From: Laura Gibbons
Sent: 11 December 2018 08:26
To: Planning.Responses
Cc: Zac Denton
Subject: RE: Planning Consultation on: M/140/18/HH

Engineers Comments Regarding Surface Water Drainage

APPLICATION M/140/18/HH

Description of Works: Rear Single Storey Extension

PROPOSED GROUND FLOOR PLAN

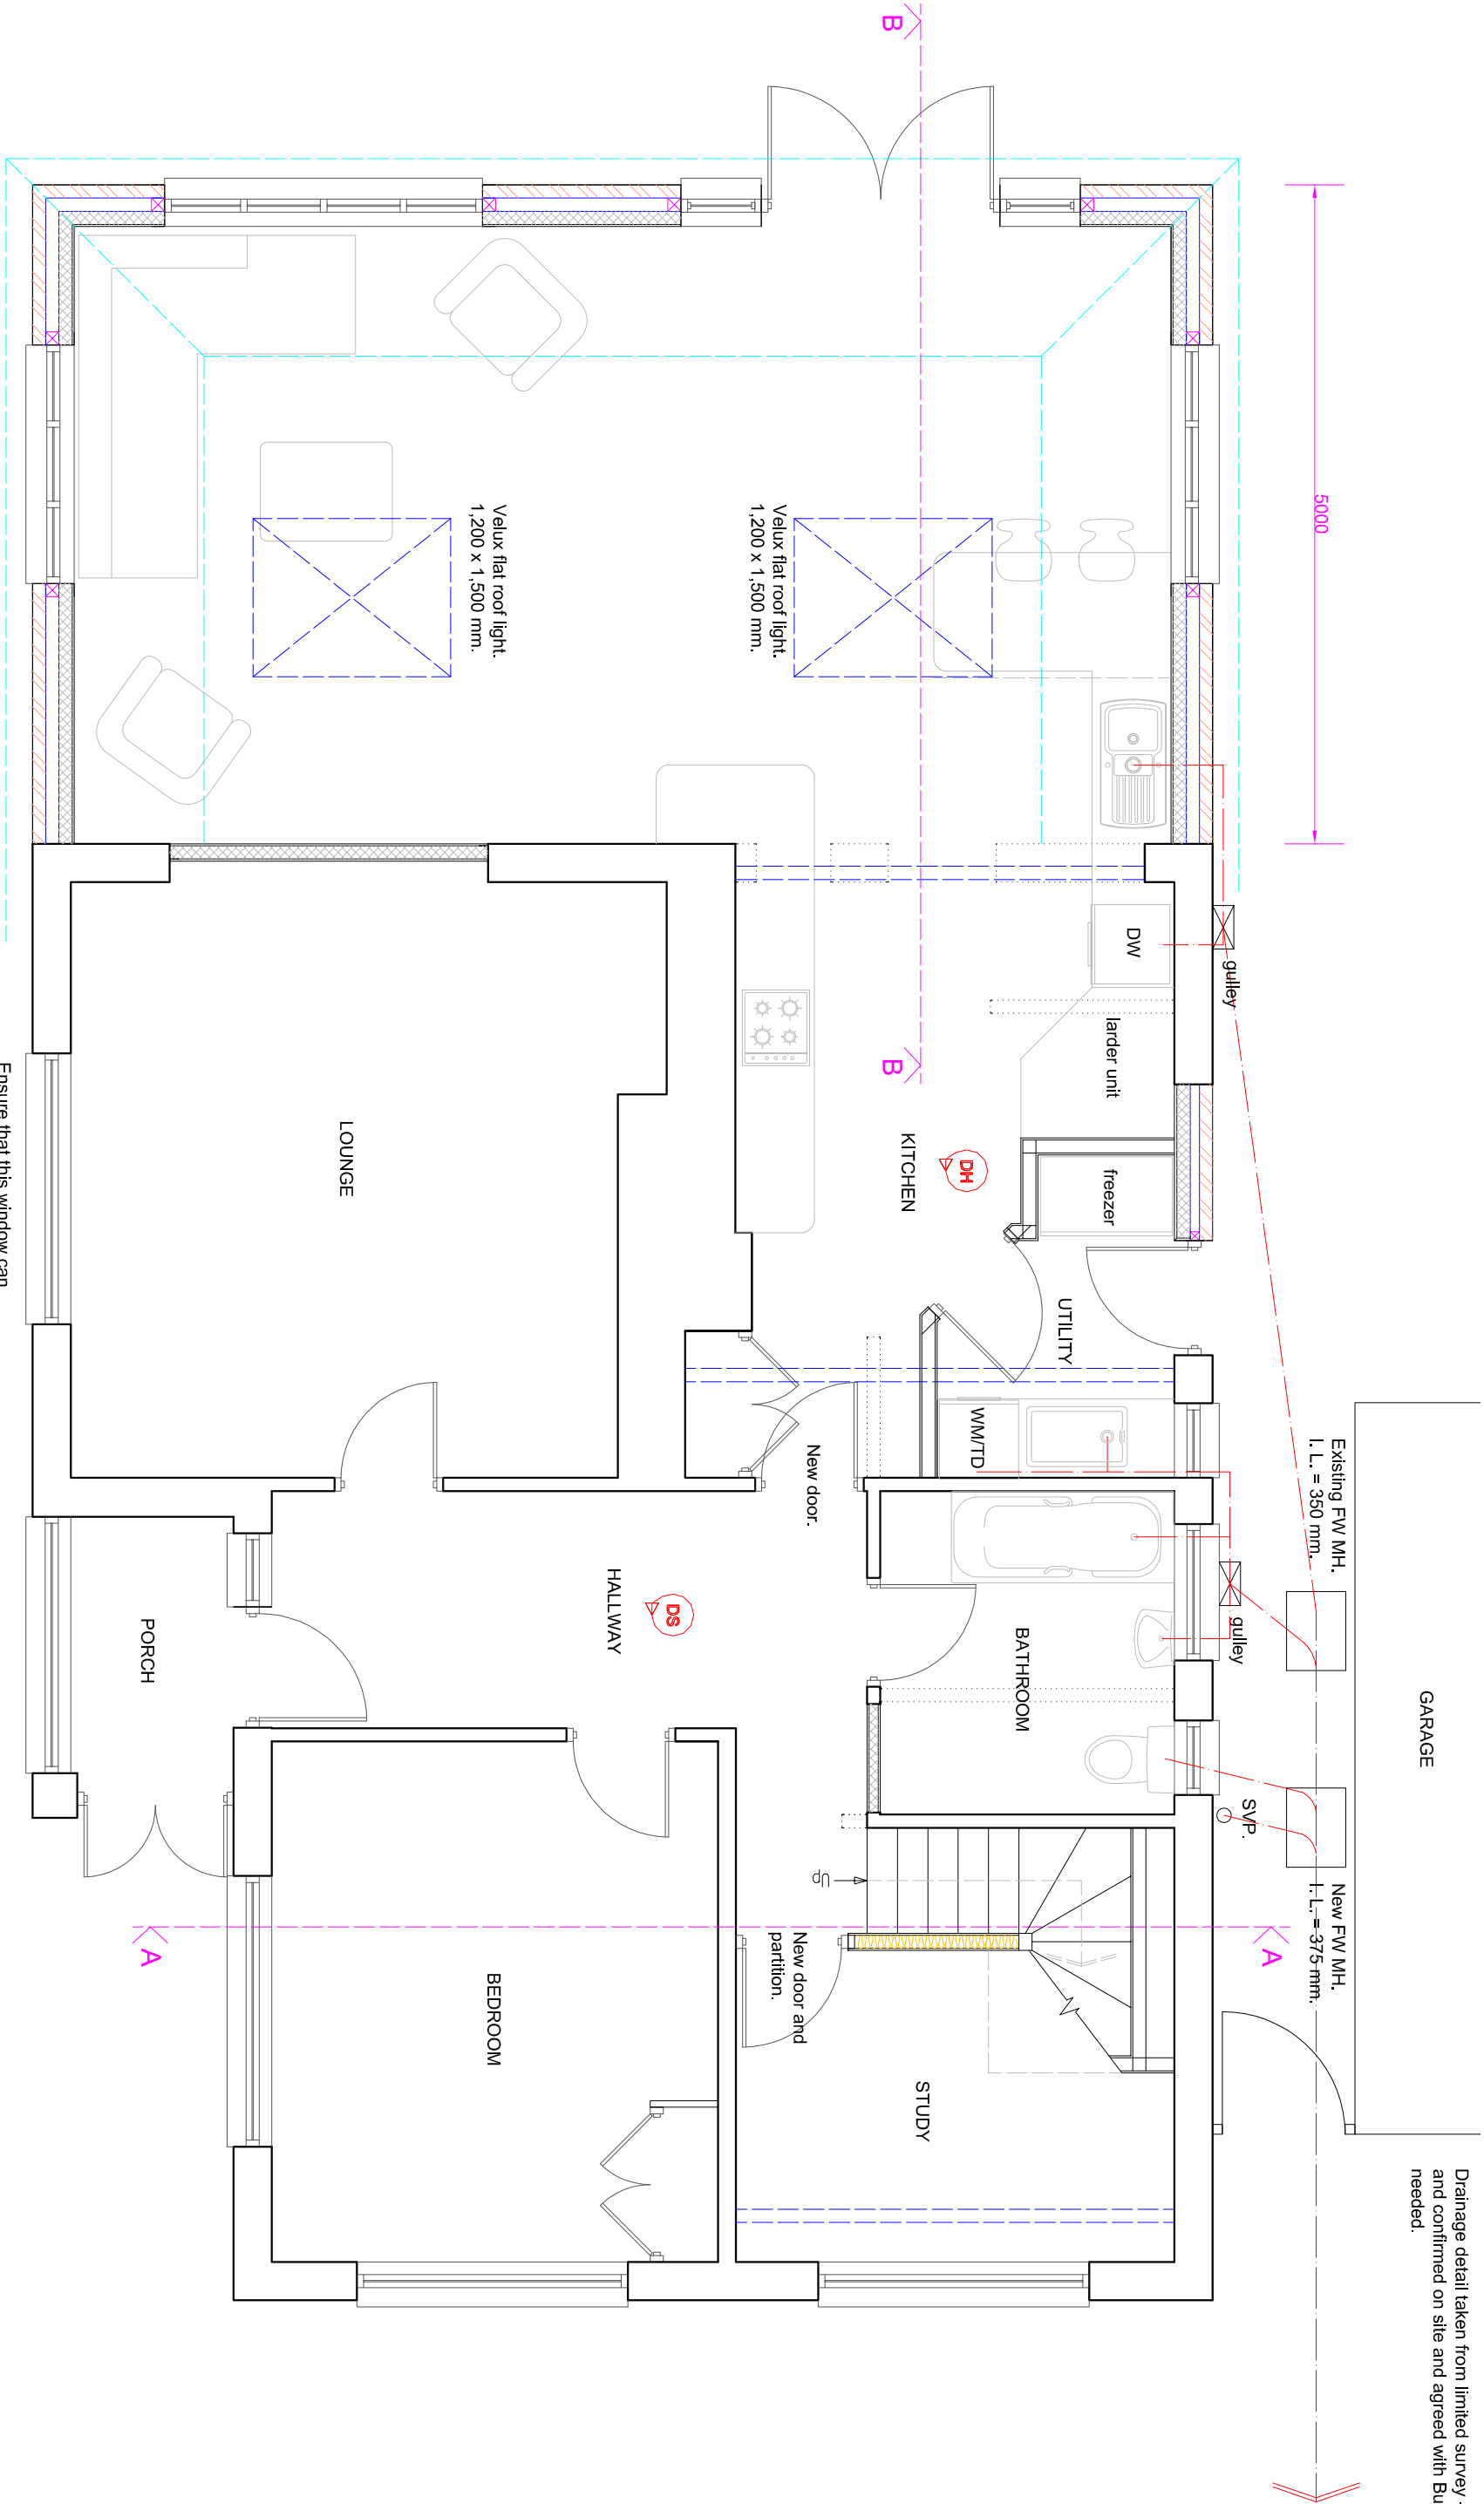
Soakaways must be investigated for surface water disposal.

Infiltration rates for soakage structures are to be based on percolation tests undertaken in the winter period and at the location and depth of the proposed structures. The percolation tests must be carried out in accordance with BRE 365, CIRIA R156 or a similar approved method and cater for the 1 in 10 year storm between the invert of the entry pipe to the soakaway, and the base of the structure. It must also have provision to ensure that there is capacity in the system to contain below ground level the 1 in 100 year event plus 40% on stored volumes, as an allowance for climate change. Adequate freeboard must be provided between the base of the soakaway structure and the highest recorded annual groundwater level identified in that location.

Any SuDS or soakaway design must include adequate groundwater monitoring data to determine the highest winter groundwater table in support of the design. The applicant is advised to discuss the extent of groundwater monitoring with the Council's Engineers. Supplementary guidance notes are also enclosed for information.

SITE PLAN - 1/500

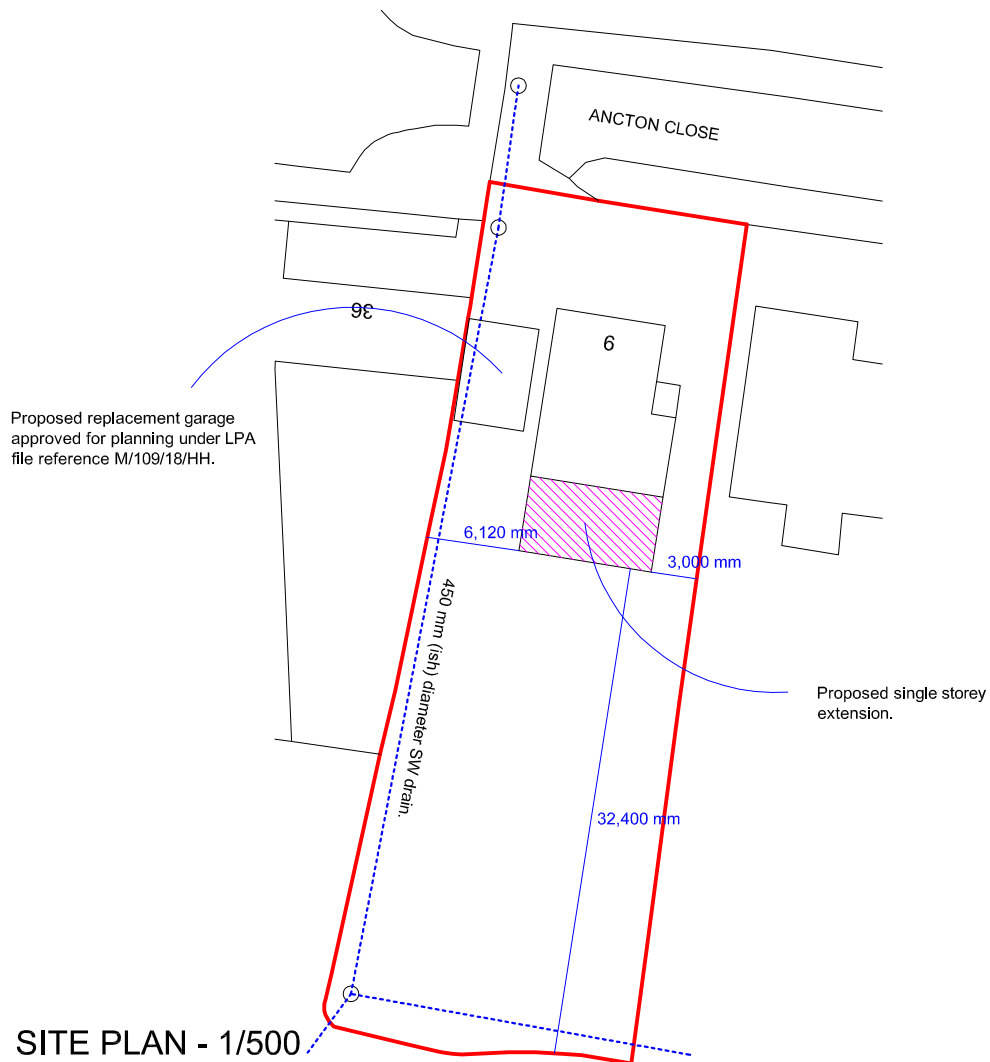
There is a culverted ordinary watercourse located within the red line boundary of this application, it's exact position should be determined by the applicant and discussions held with us.
